**PLANNING ACT 2008
APPLICATION BY HIGHWAYS ENGLAND FOR AN ORDER GRANTING
DEVELOPMENT CONSENT FOR THE A303 SPARKFORD TO ILCHESTER
DUALLING
SUBMISSION MADE PURSUANT TO DEADLINE 8**

PLANNING INSPECTORATE REFERENCE TR010036

PLANNING ACT 2008 - APPLICATION BY HIGHWAYS ENGLAND FOR AN ORDER GRANTING DEVELOPMENT CONSENT FOR THE A303 SPARKFORD TO ILCHESTER DUALLING

SUBMISSION MADE PURSUANT TO DEADLINE 8

2.4 Rights of Way and Access Plans

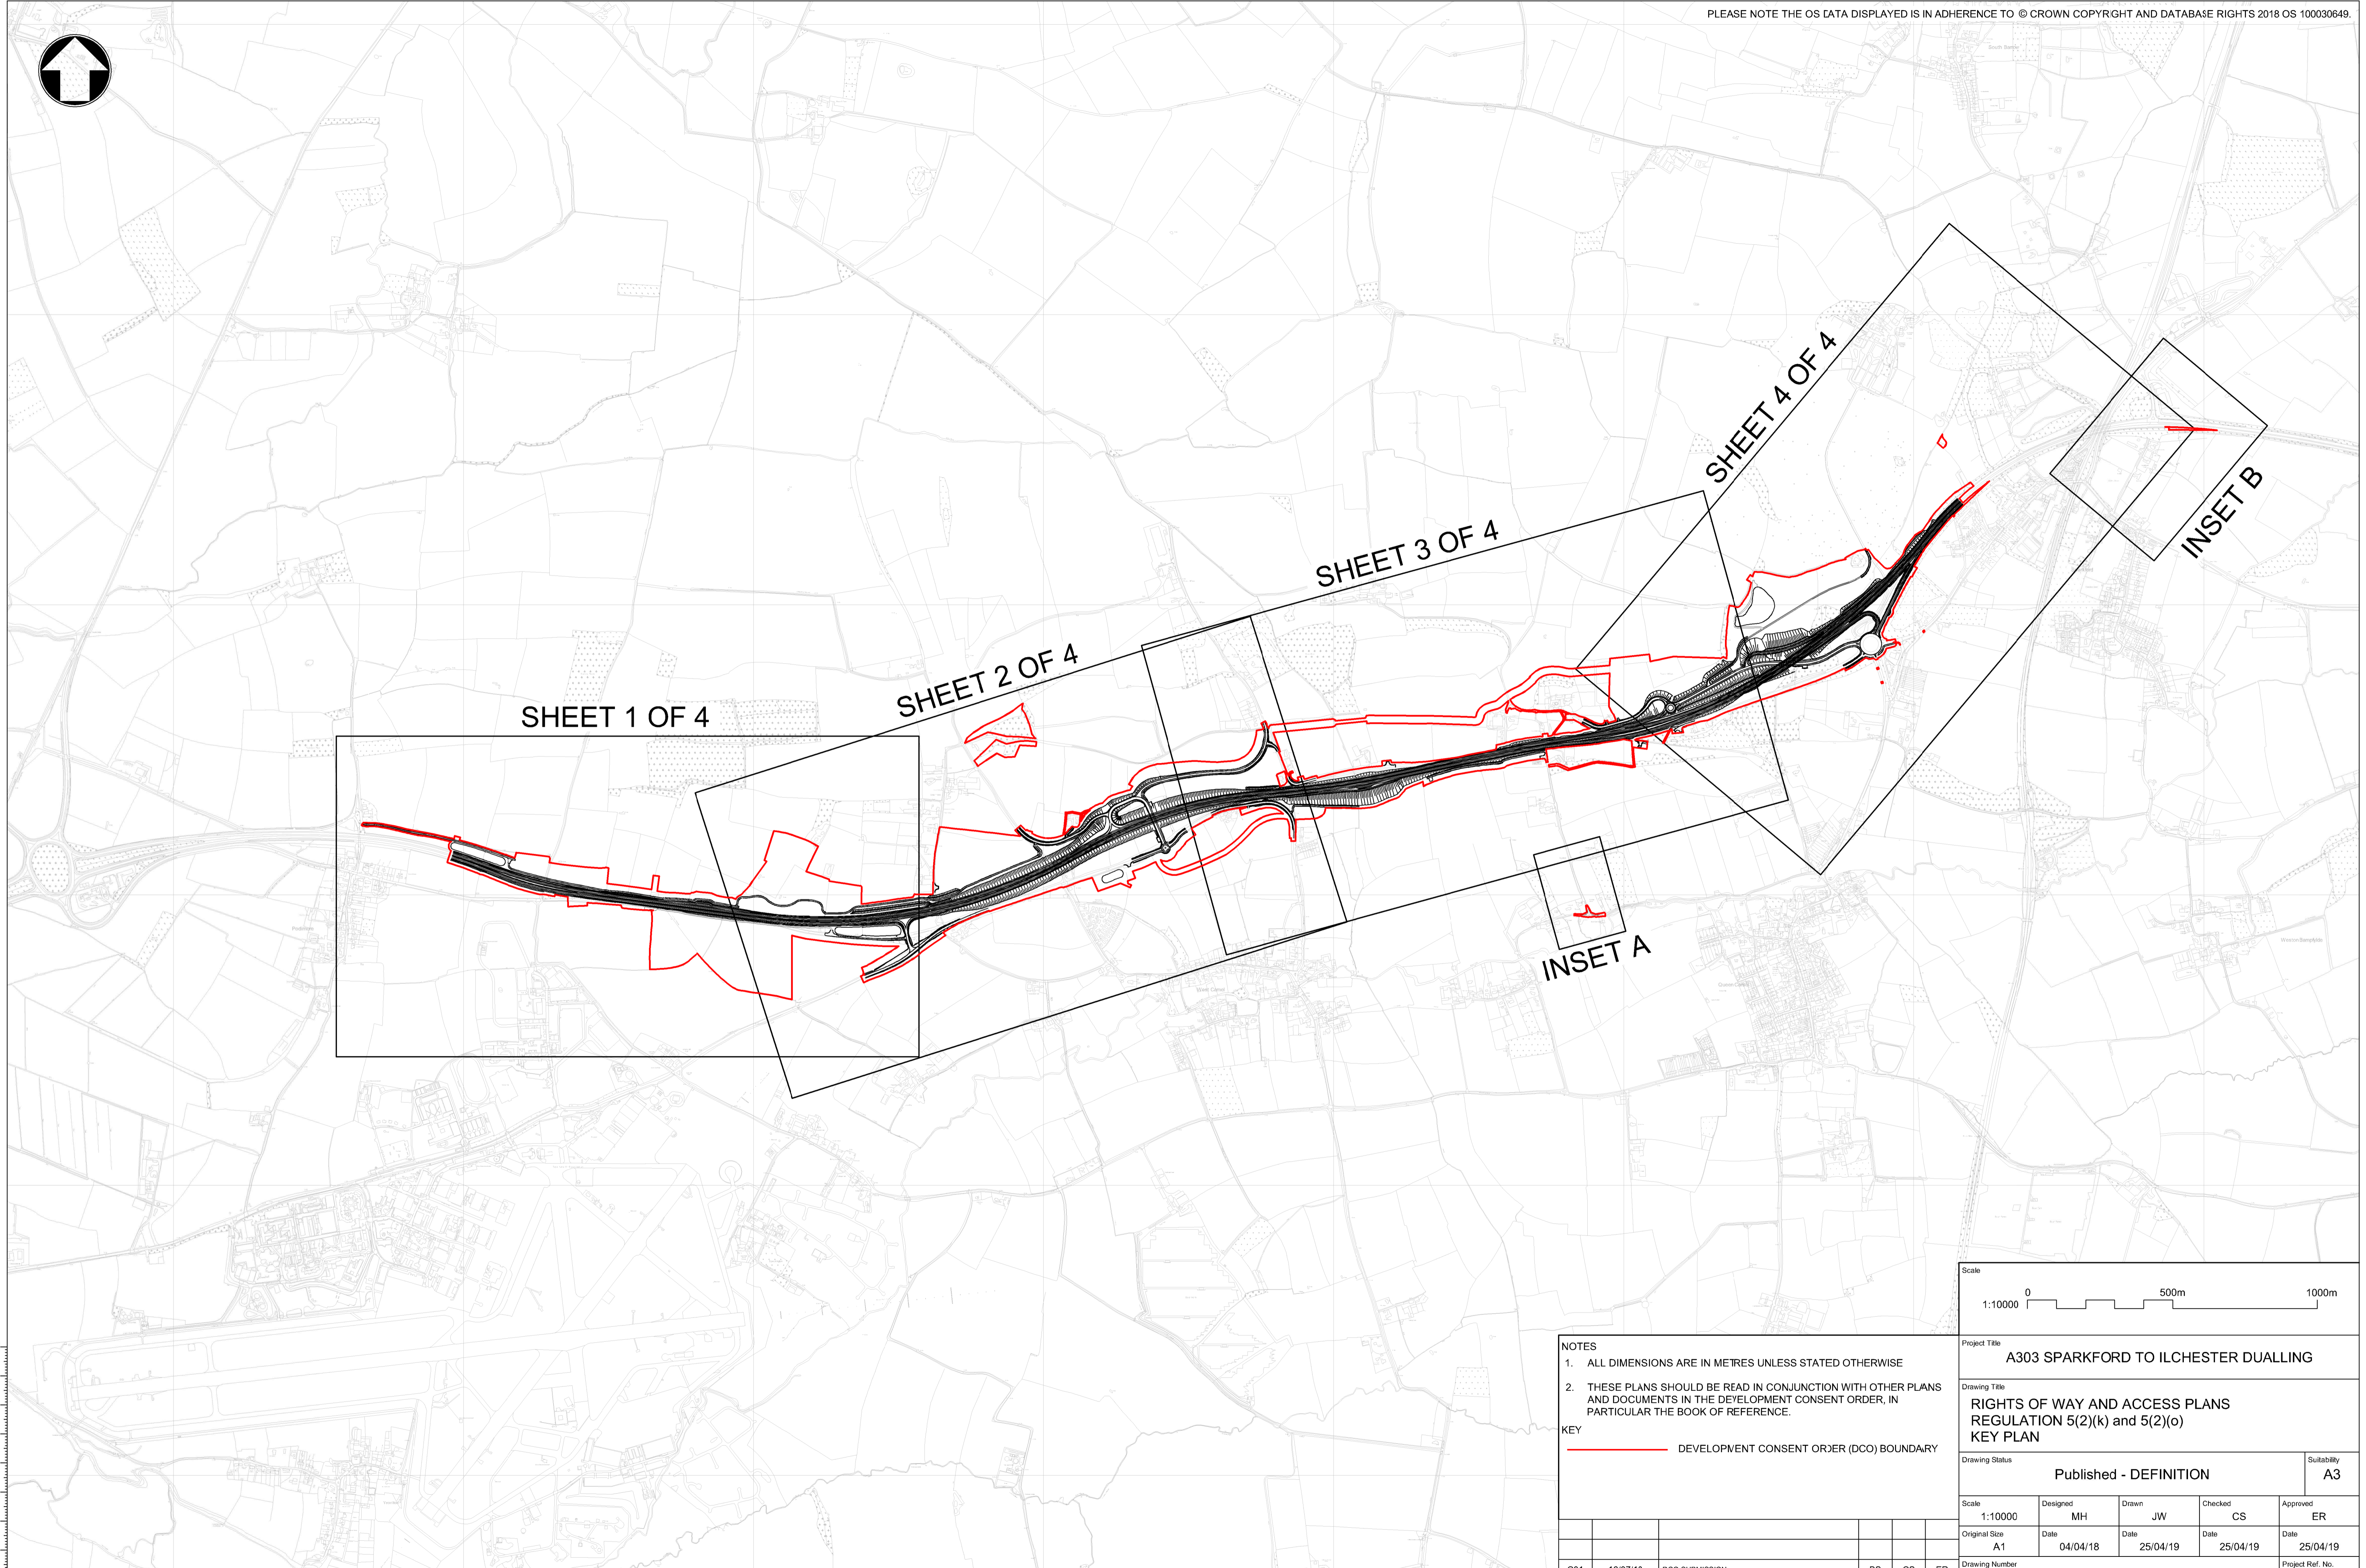
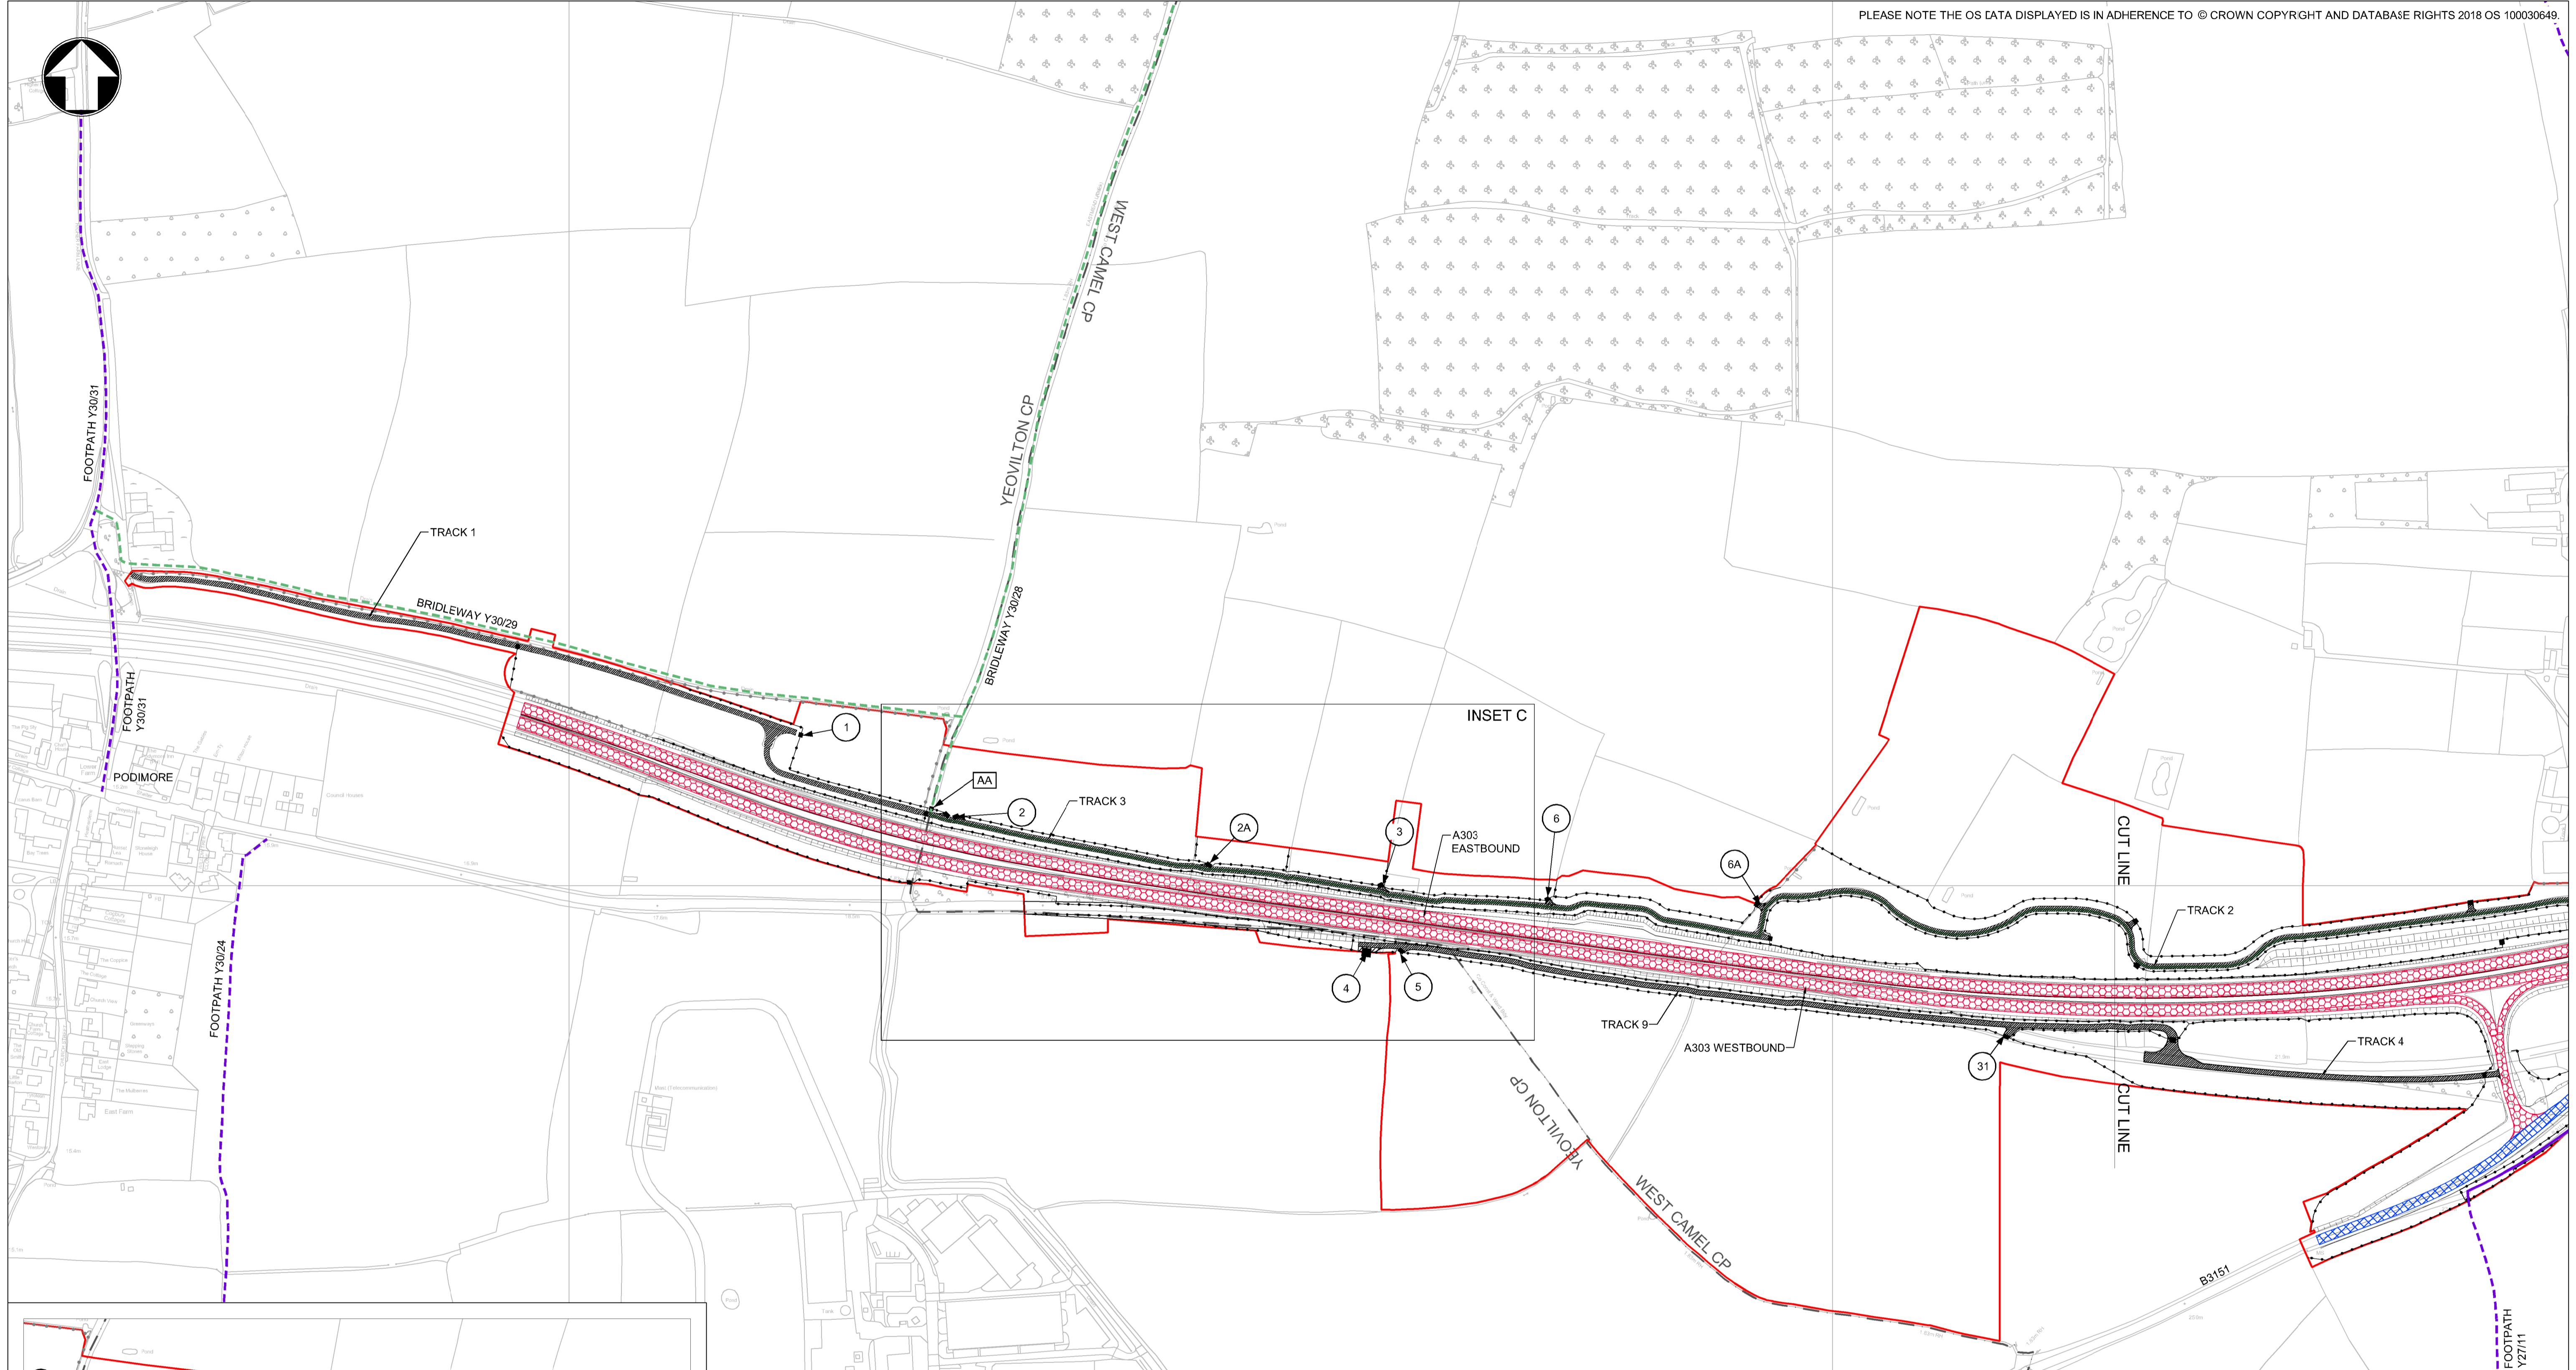
Reference	Action	Response location
Way and Access Plans		As per the County Council's deadline 6 submission, references in the DCO and the Rights of Way & Access Plans require amending; Y 27/29 should now be shown as Y 27/UN, and Y27/36 should now be shown as Y 27/29. If the County Council is to update the Definitive Map & Statement with the effect of the DCO then these changes are critical.
